Access Assessment Report

St Aloysius College, Rozelle

Project:	St Aloysius College, Rozelle
Reference No:	113752-Access-r1
Date:	25 October 2021
Client:	PMDL Architecture & Design Pty Ltd
Client Contact:	Andrew Pender
Email:	apender@pmdl.com.au
BCA Logic Project:	Ben Long
Direct:	8484 4009
Email:	blong@bcalogic.com.au

48 Victoria Rd-Proposed Plan L1 St Aloysius College-Rozelle Campus

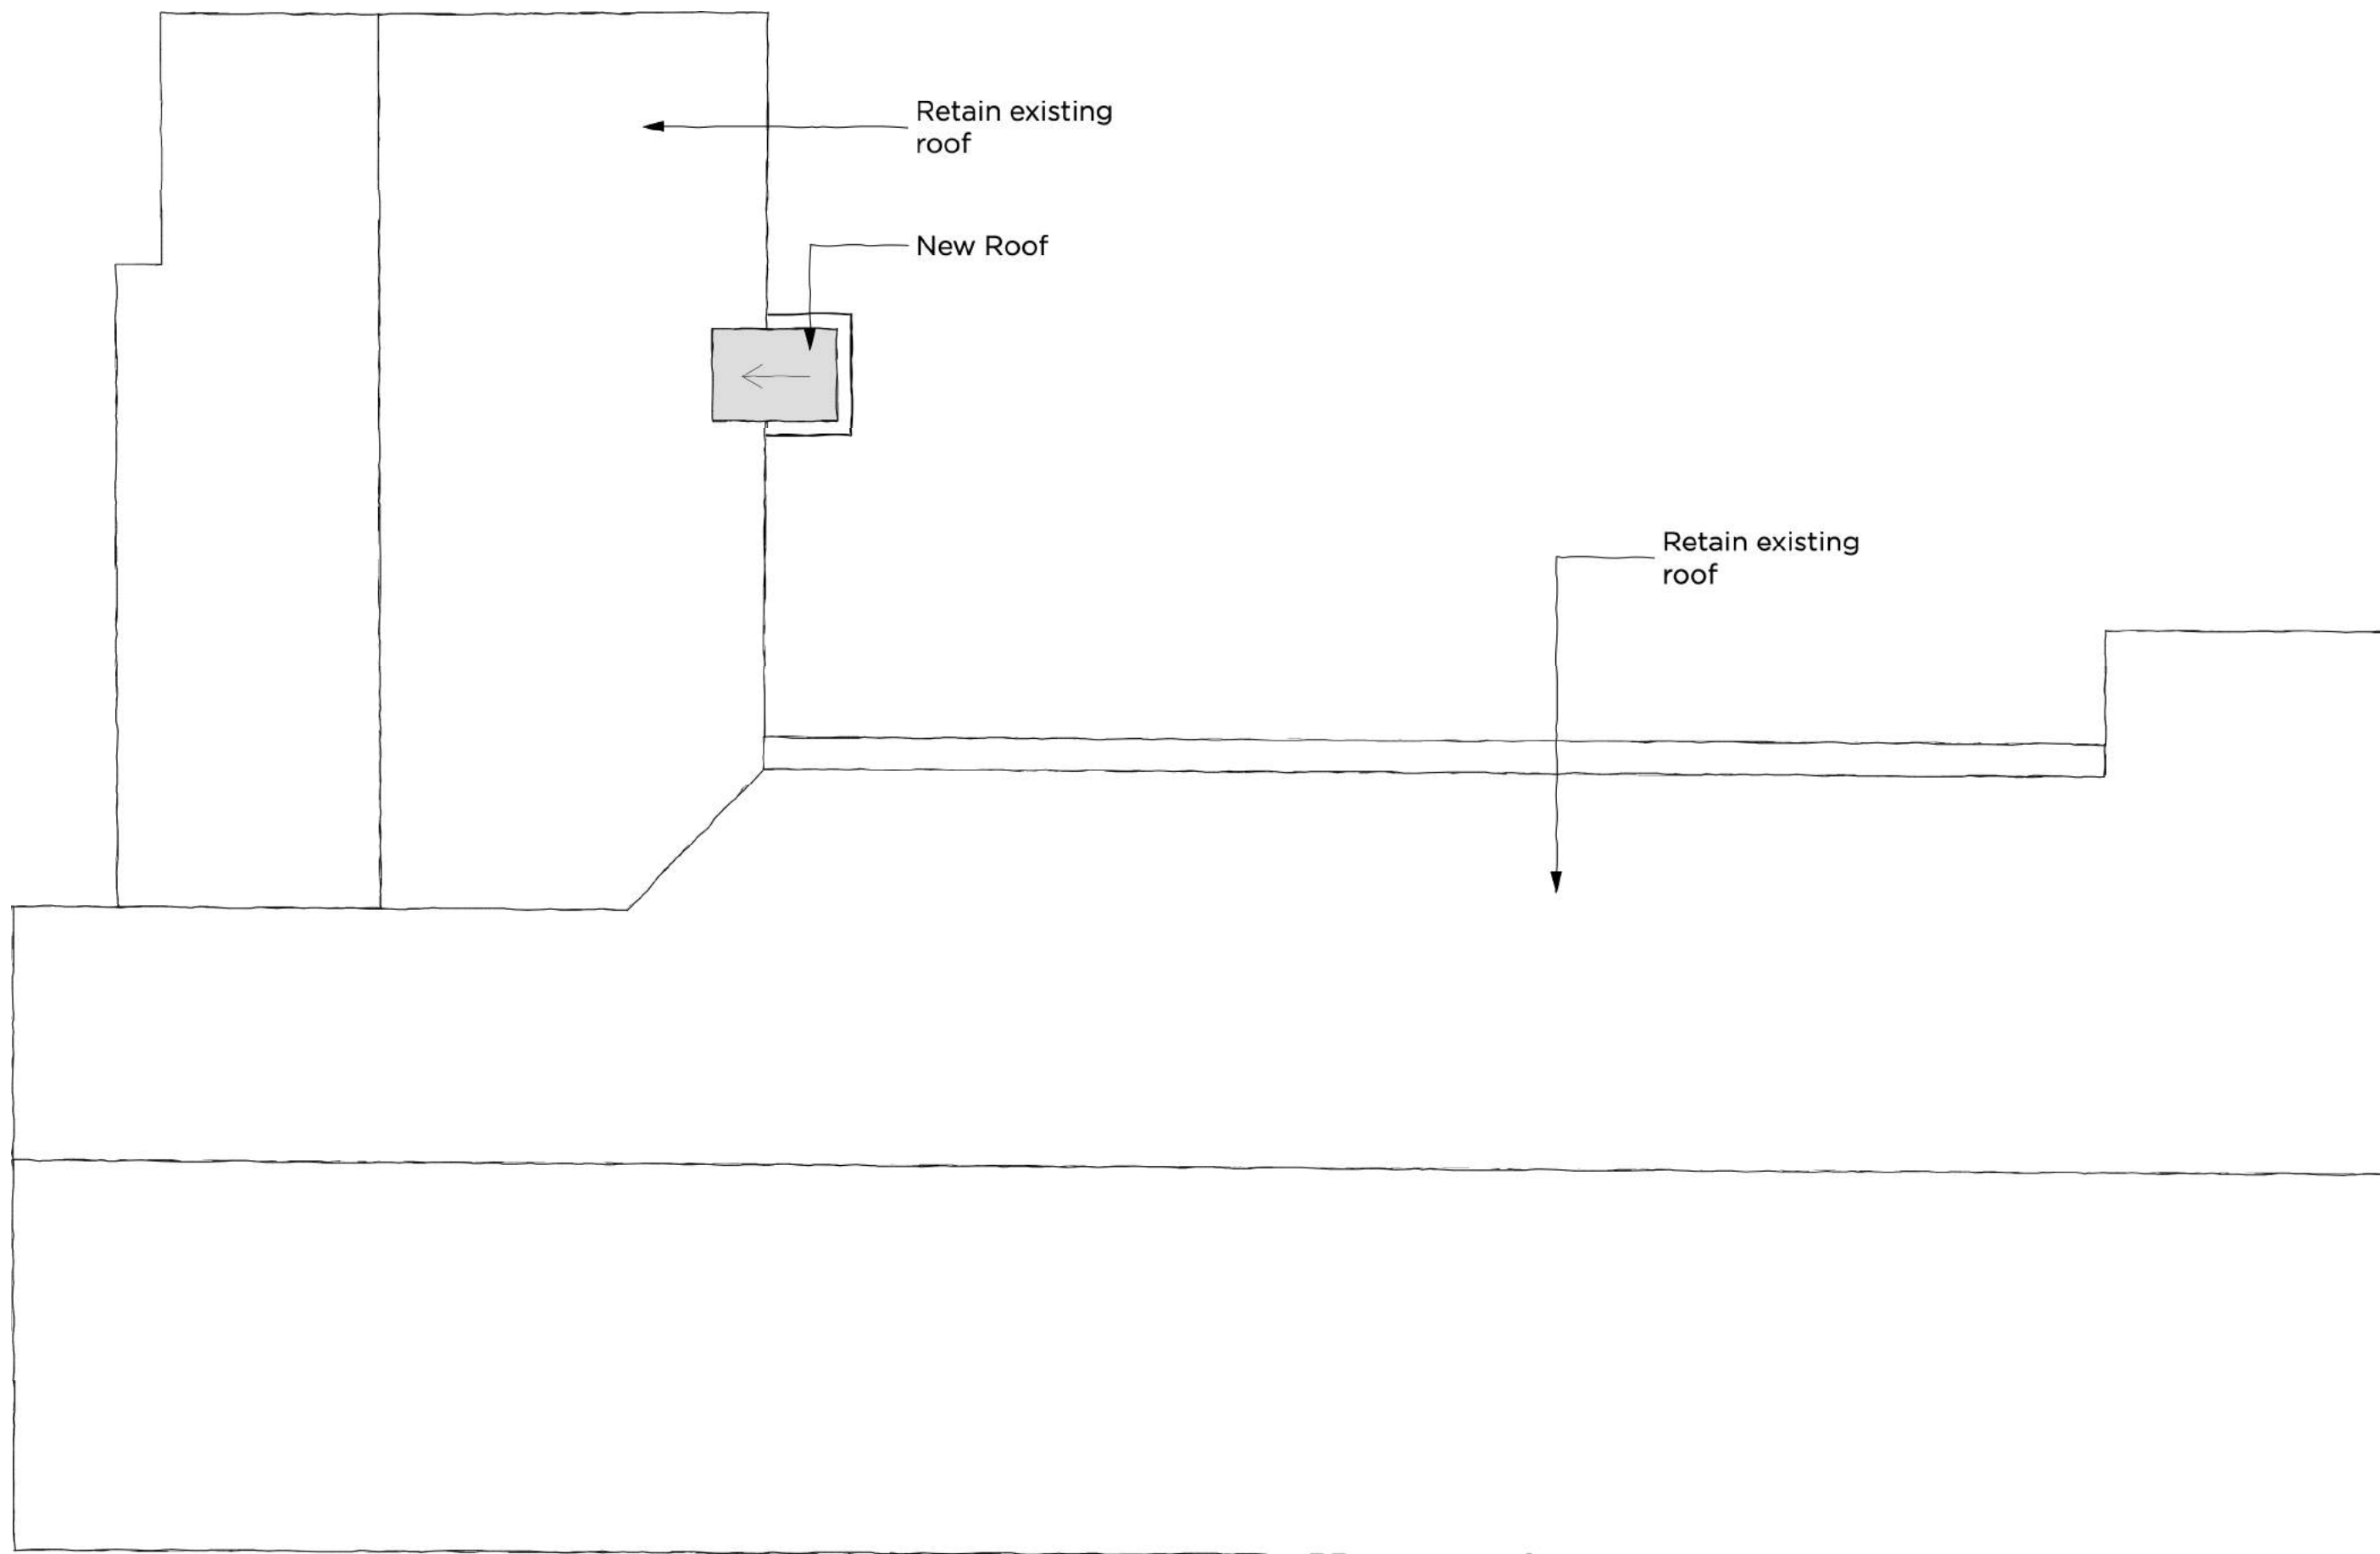
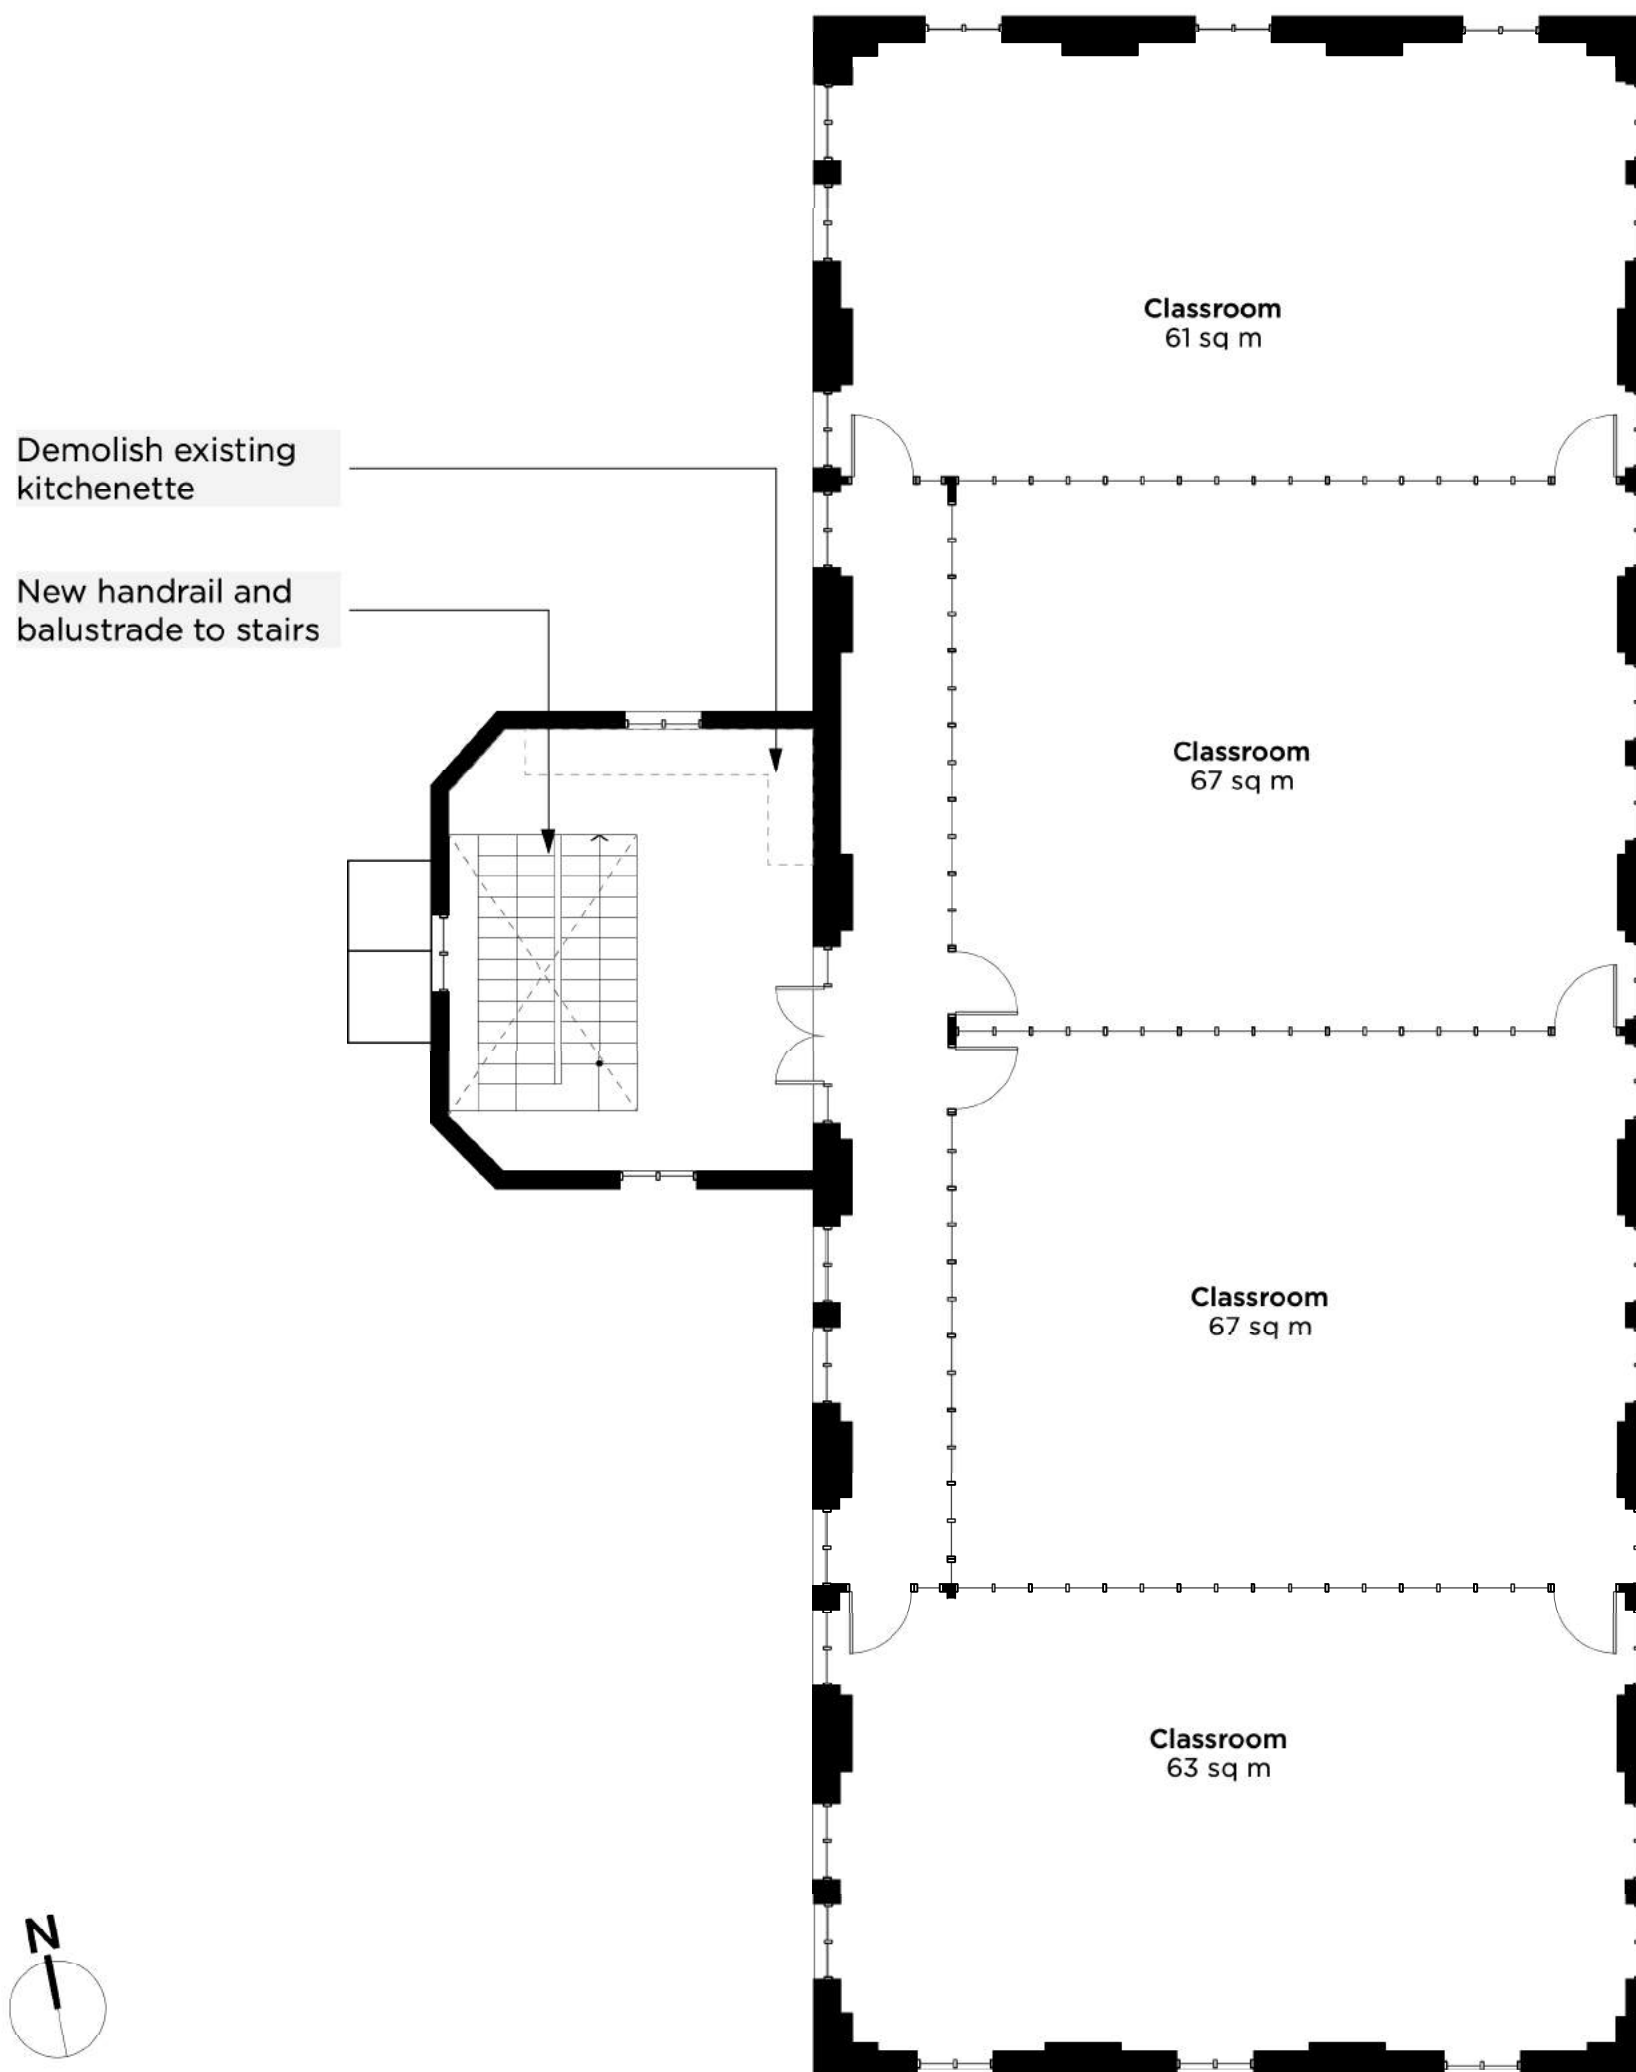
It is noted that as part of the new works the Music Practice Rooms are required to be accessible and will required compliant door circulations in accordance with AS1428.1-2009. Confirmation would be required that the corridor will provide a clear width of at least 1240mm to allow for compliance being achieved.

When reviewing the proposed accessible sanitary facility, the latchside clearance within the room would not be maintained due to the location of the handwash basin?.

As part of the detailed design and ongoing documentation it would be required that the plans are to swing the door inside the sanitary compartment but have the basin located 300mm clear of the door swing in accordance with AS1428.1-2009.

Additionally, it is noted that only a single ambulant sanitary compartment is proposed for the staff facilities. As part of the BCA Report, it is required that two of these WCS are allocated to Female and one WCs is allocated to male. Therefore, it would be required that there are two ambulant facilities provided in accordance with AS1428.1-2009.

As part of the detailed design and ongoing documentation it would be required that the plans are updated to include an ambulant facility for male and for female use.
